From: Tim Smith <tsmith@wsaco.com.au>
Sent: Tuesday, 15 December 2020 5:07 PM
To: David Schwebel
Cc: Kirk Osborne; Planning and Safeguarding
Subject: [SEC=OFFICIAL] RE: Aldington Industrial Estate Referral SSD10479

Thank you for your email seeking feedback in regards to the proposed Industrial Estate at 200 Aldington Road (SSD-10479). WSA note the proposal is for the development of a series of warehouse format developments approximately 5km away from the airport. The site forms part of the Mamre Road Precinct, located in the Western Sydney Employment Area, and has been proposed in accordance with *State Environmental Planning Policy (Western Sydney Employment Area) 2009*.

Drawing Title **Landscape Concept Master Plan**

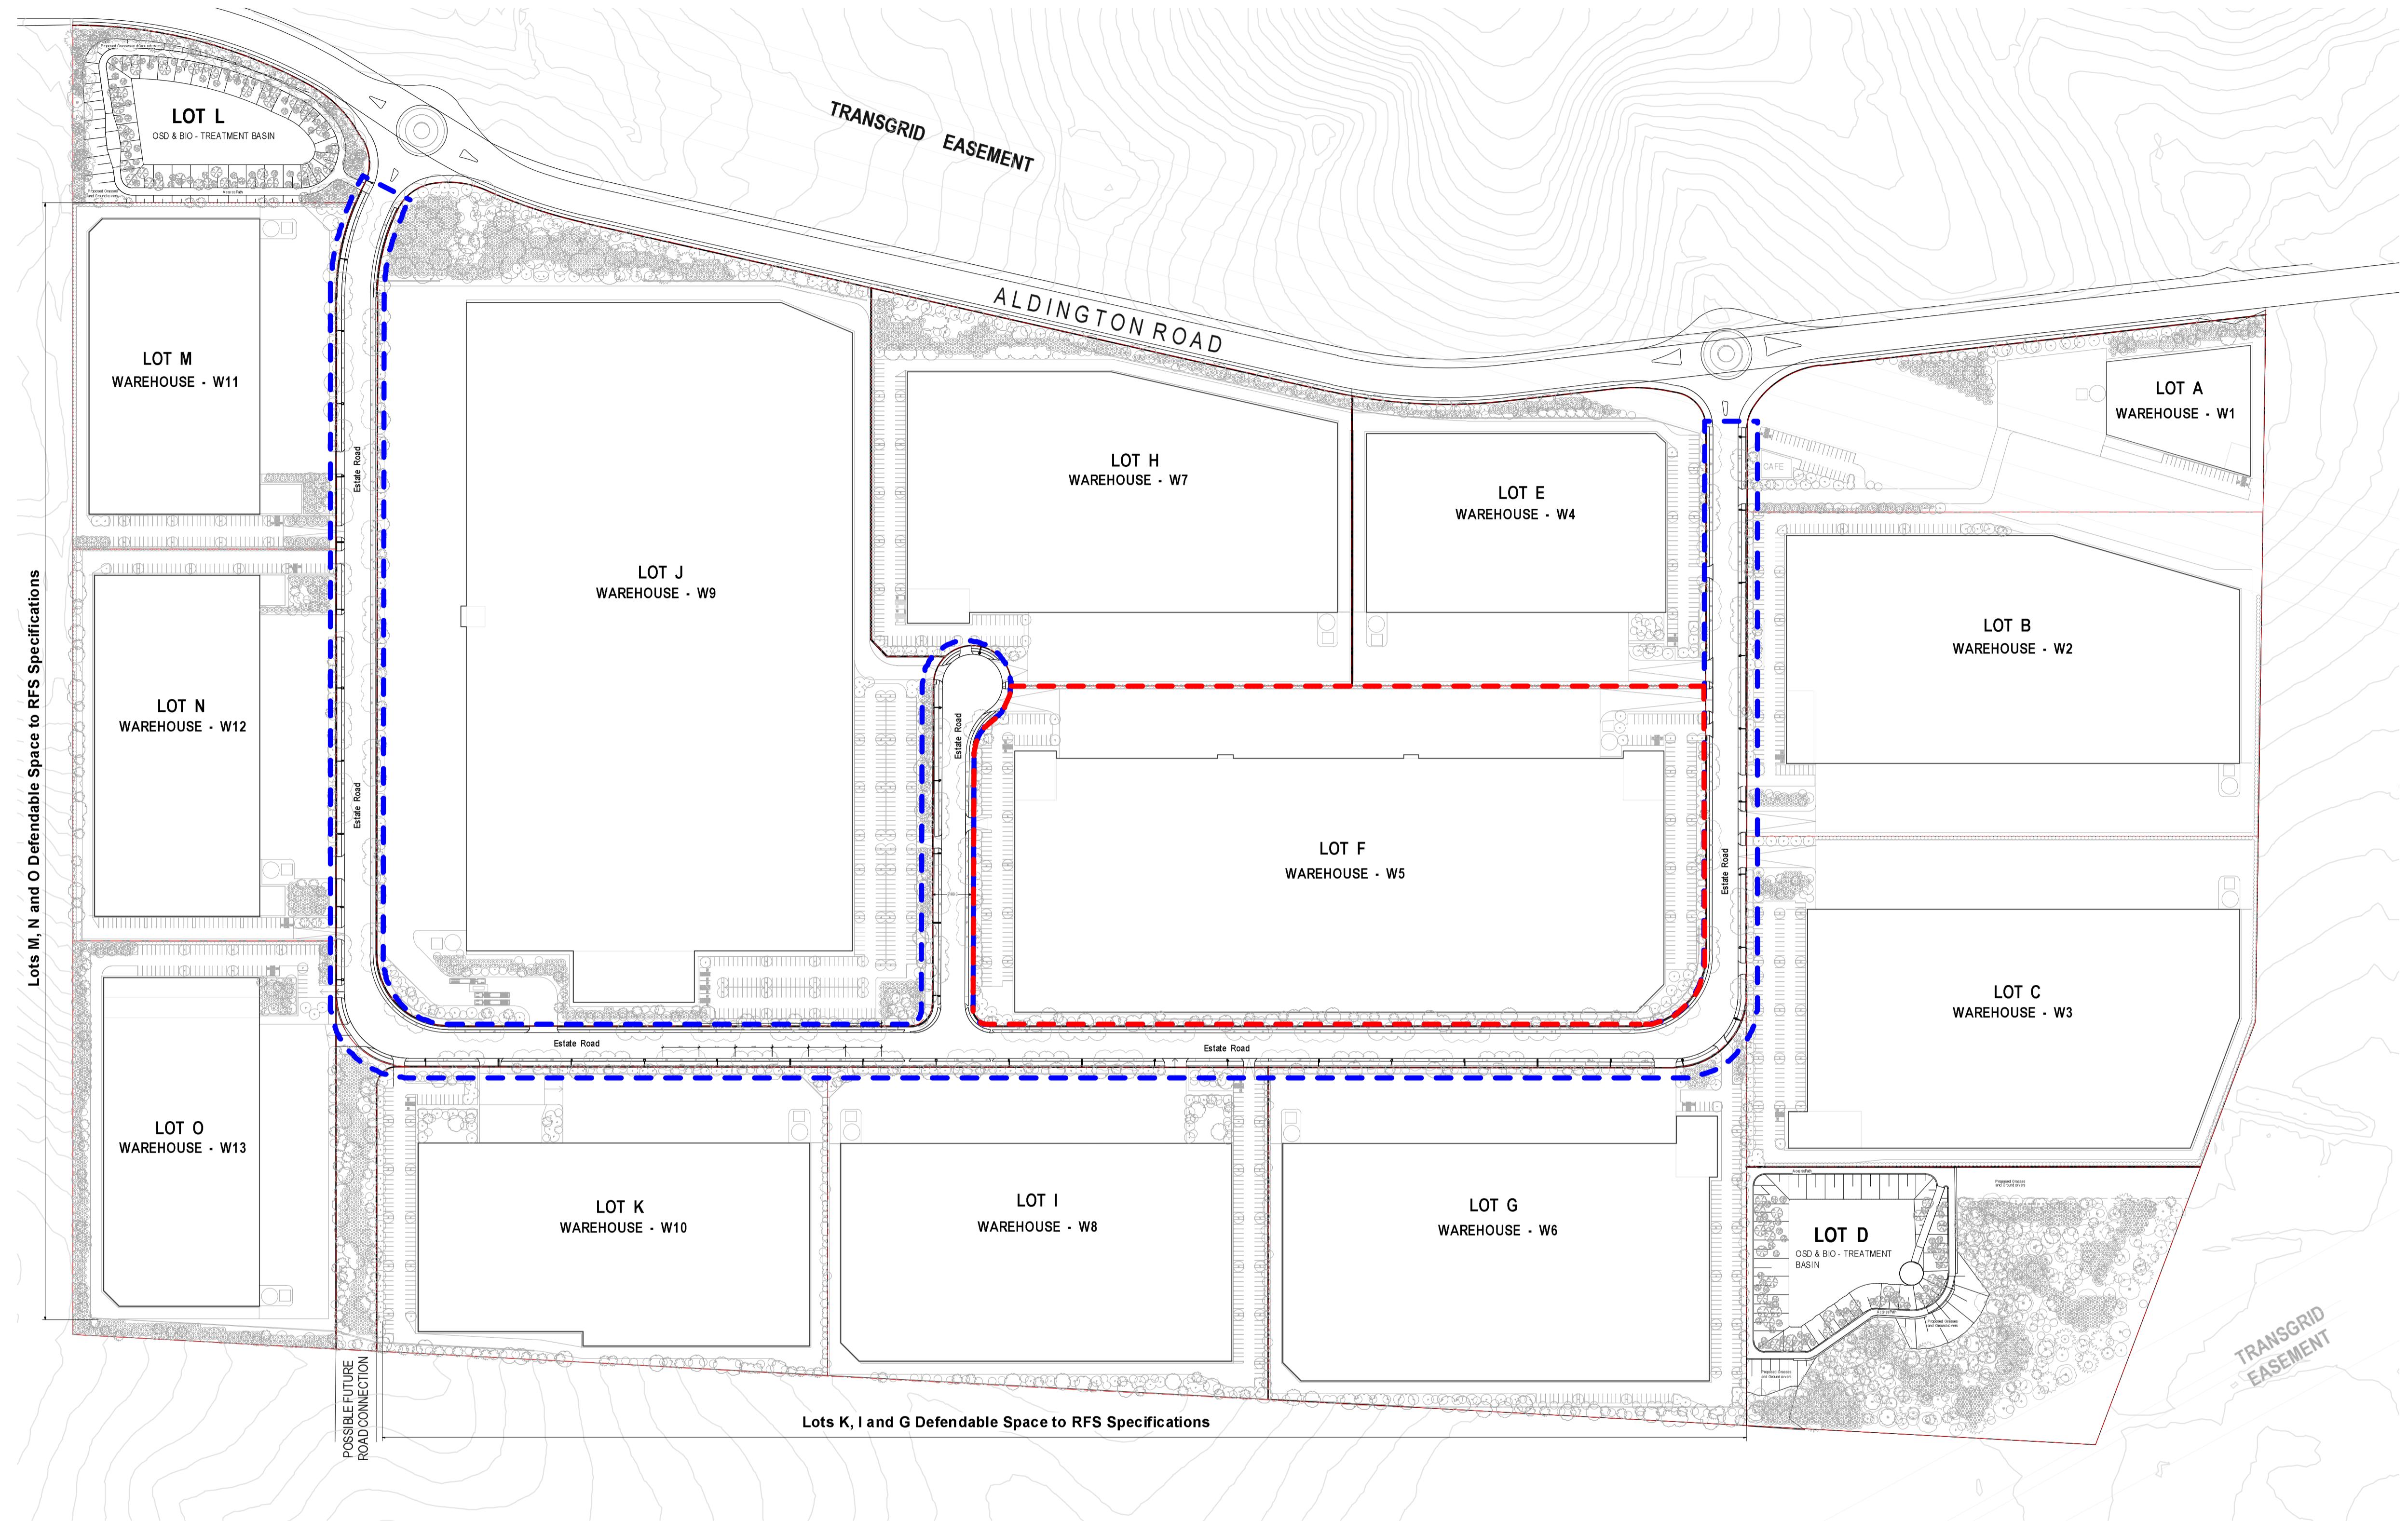
- **Wildlife Hazards – Vegetated Areas:** The proposed development includes new basin and vegetation management zones, which are identified as being planted with native species, and providing a habitat for fauna in the area (Page 91). It should be ensured that this wildlife zone does not present an increased risk of wildlife attraction in relation to the future airport. The proposal includes the realignment of an environmental corridor along the northern boundary of the site, and the provision of a riparian zone, including planting along the realigned corridor. The proposal also includes the provision of a stormwater basin on site. It should be ensured that this wildlife zone does not present an increased risk of wildlife attraction in relation to the future airport. The Aeronautical Impact Assessment that forms part of the DA package does not address the risk posed by these factors. Landscaping species should be selected to deter the attraction of birds / flying foxes.
